Elmbridge Borough Council

26 November 2019

RE: Written Representation request in Planning Act 2008 – Section 89 and The Infrastructure Planning Examination Procedure Rules 2010 – Rule 8 etc

Elmbridge Borough Council (the Council), gives its general support to the aims of the Highways England (Applicant) M25 Junction 10/A3 Wisley interchange improvement project to reduce congestion, improve safety, support planned housing and economic growth and improve provision for pedestrians, cyclists and horse riders, but also continues to work to ensure the impacts of the project to residents and areas within Elmbridge Borough are properly mitigated.

Figure 5.1 – Revised Layout of A245 Eastbound Carriageway

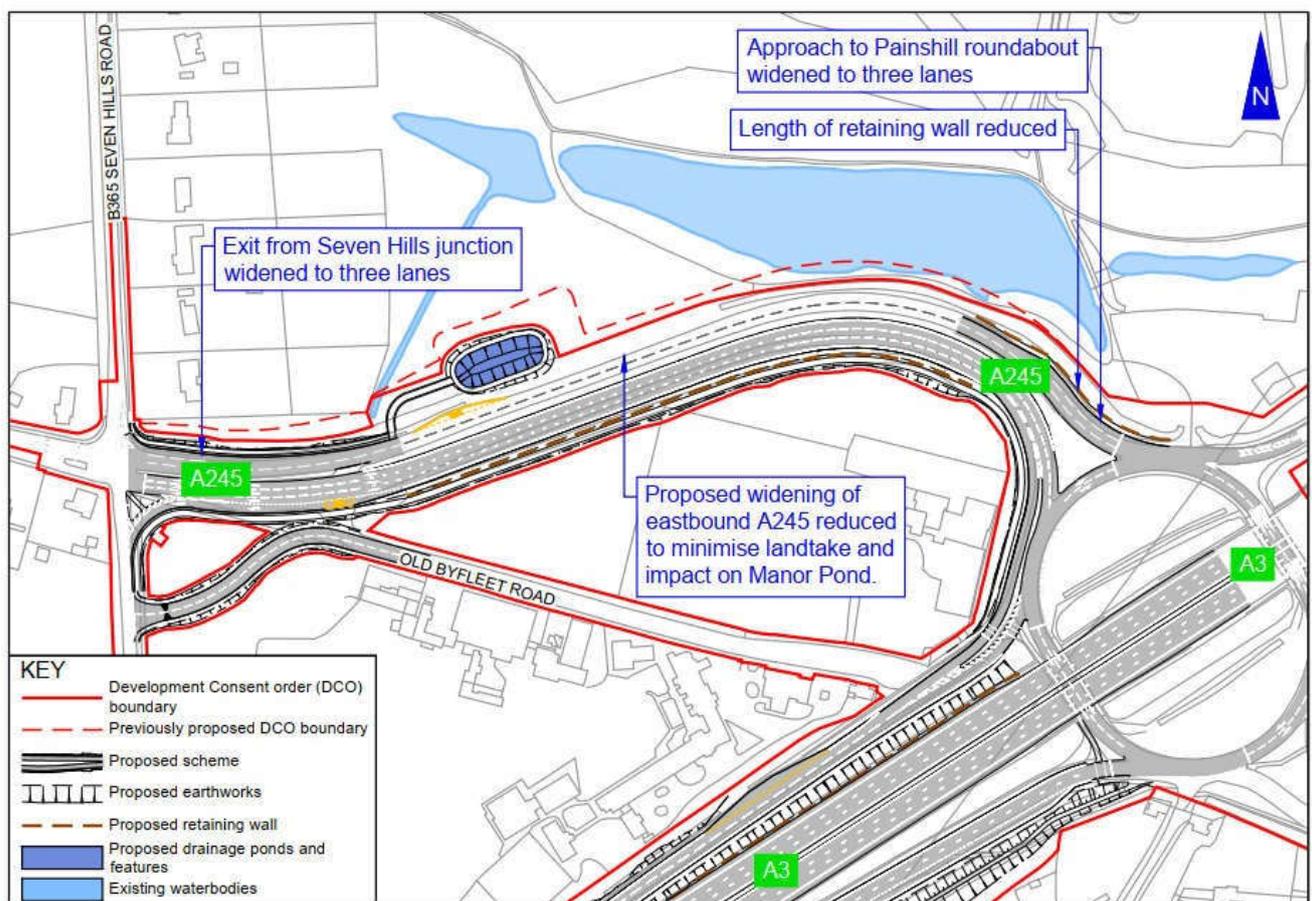
The Council also strongly supports the suggestion of the Applicant working to link the Painshill and A245/Seven Hills Road traffic signal controls to improve the flow of traffic, especially with this being a primary route created by the banned right hand turn from Seven Hills Road. The proposed Change 3 (AS-023) to remove the retaining wall Work No. 47(c) and therefore only provide two lanes toward

the Painshill junction instead of the proposed three lanes when traffic will reroute in this direction was unexpected. The Council notes SCC comments requiring revised information to demonstrate the proposal would provide benefits to the LRN and mitigate the impact of the scheme both for traffic flow and users of the footpath proposed in the original design.
